PLANNING AMENDMENT

| CURRENT APPLICATION NO: This amendment cannot be considered unless the relevant reference is stated. | | H16-0217-25 and H16-0218-25 | |

| FULL DESCRIPTION OF DEVELOPMENT OF CURRENT APPLICATION THAT THIS AMENDMENT RELATES TO | Conversion of first, second and third floors to residential flats together with alterations to shopfront and rear of building. | |

Drawing Number:	<b>A1727 - 10</b>	Rev:	<b>P3</b>
-----------------	-------------------	------	-----------

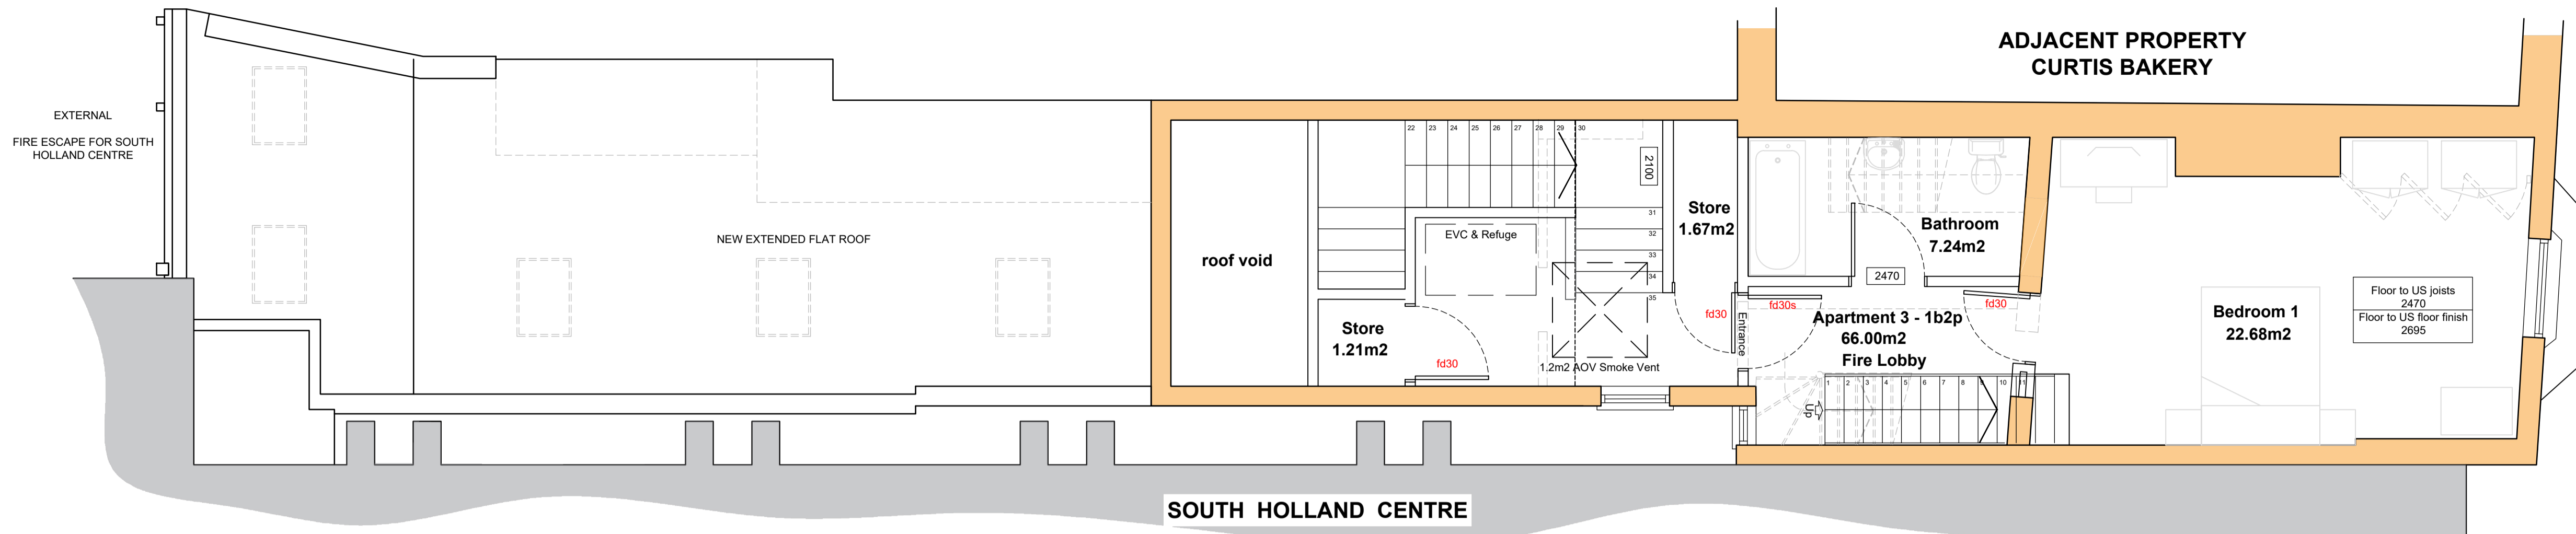
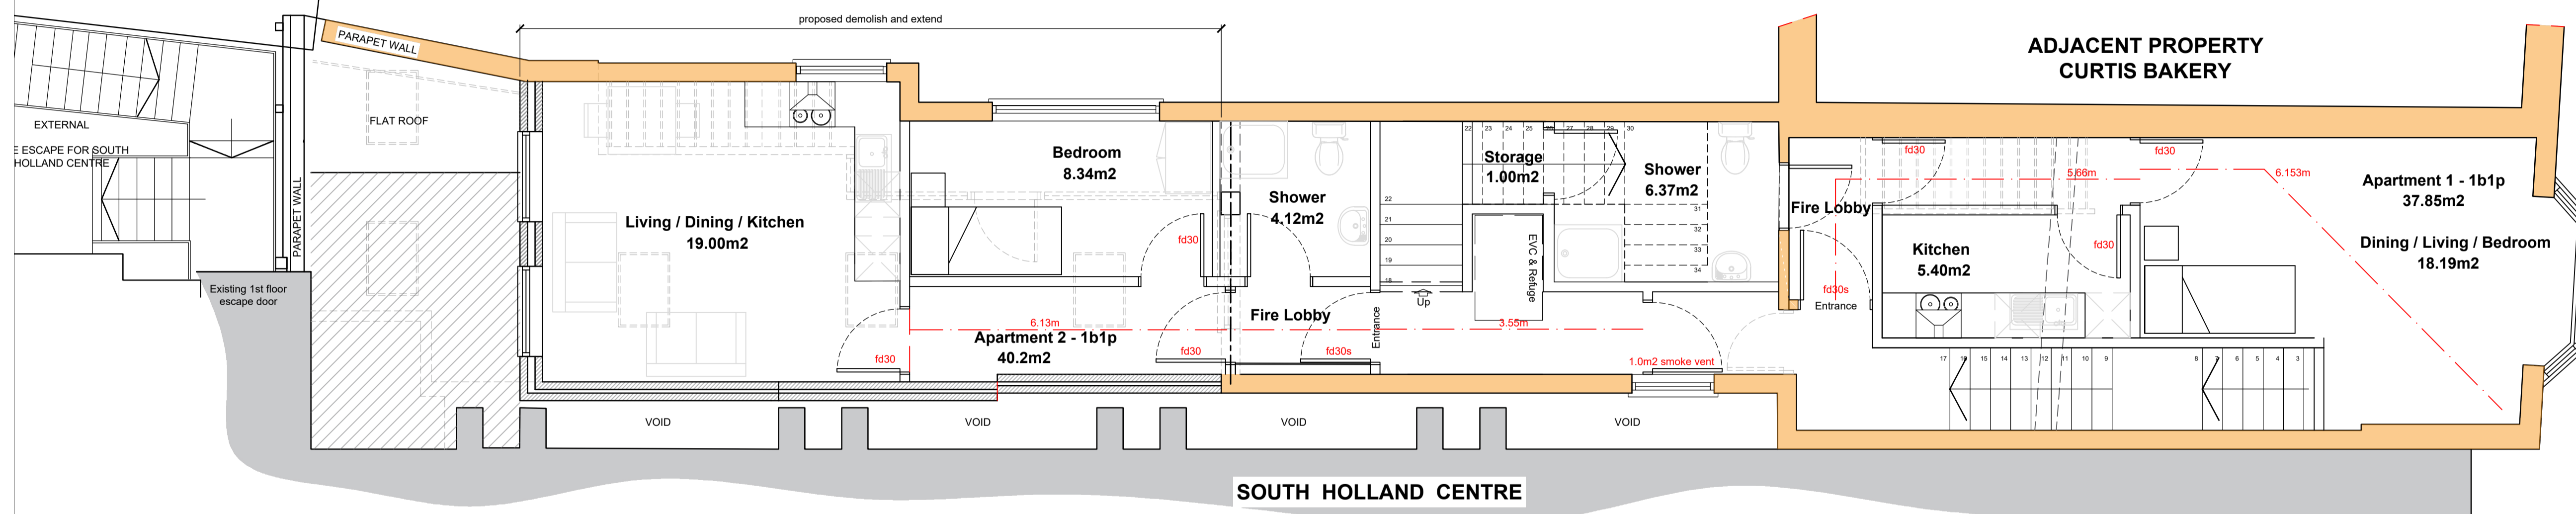
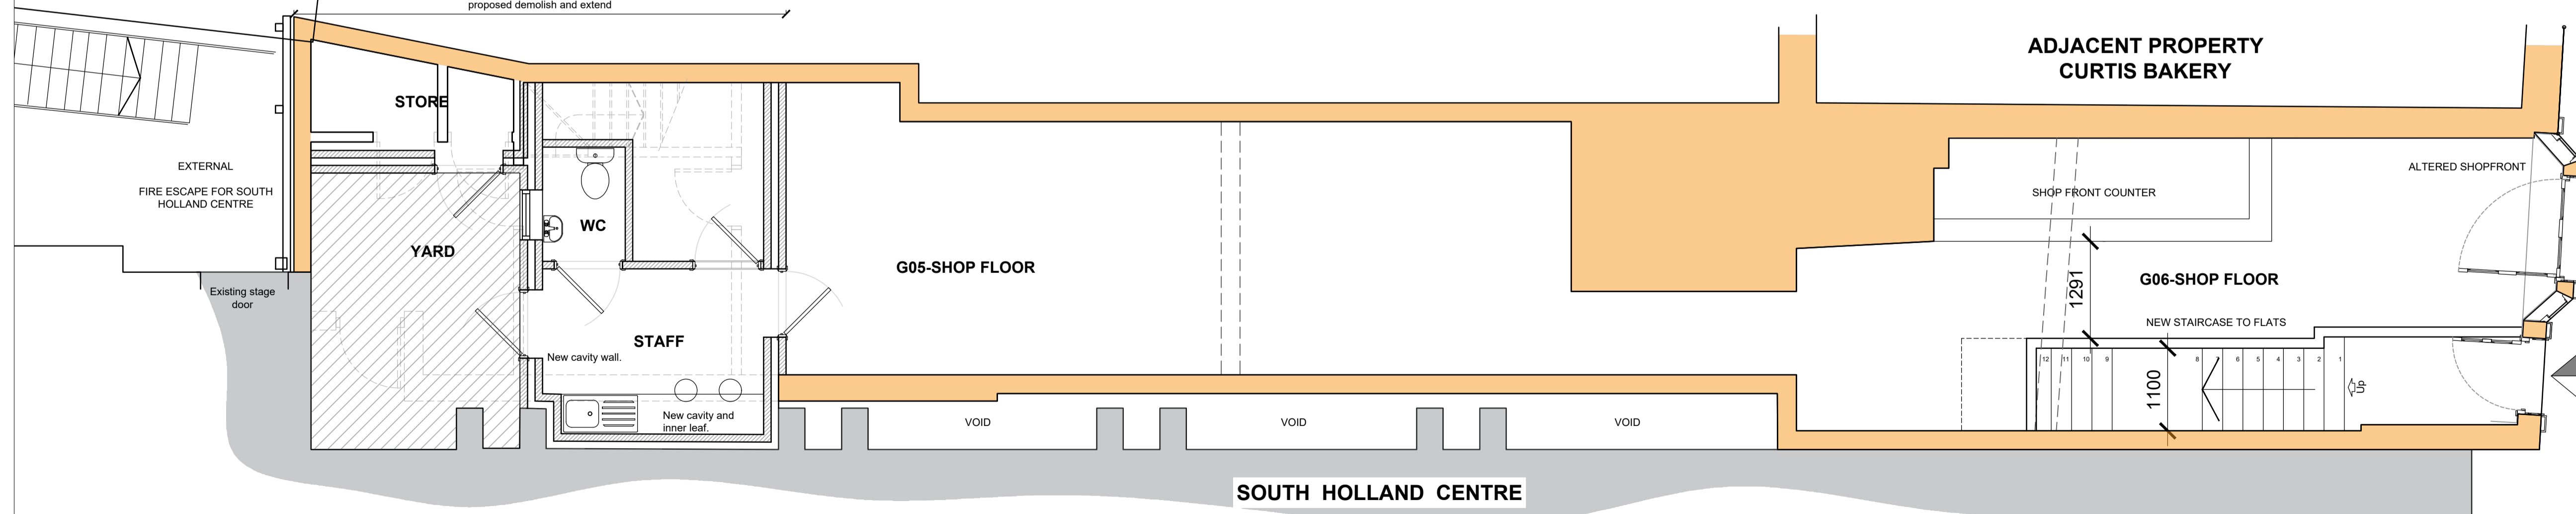
| State details of amendments proposed. (Give a full detailed list of the changes; and also mark these clearly on the accompanying plans. Only the changes listed here will be considered) | Bay window and shopfront to ground floor amended following further survey works and dialogue with planning and conservation officers. | |
| State drawing numbers of the current submission | A1727-10 rev P3 and A1727-12 rev P3. | |
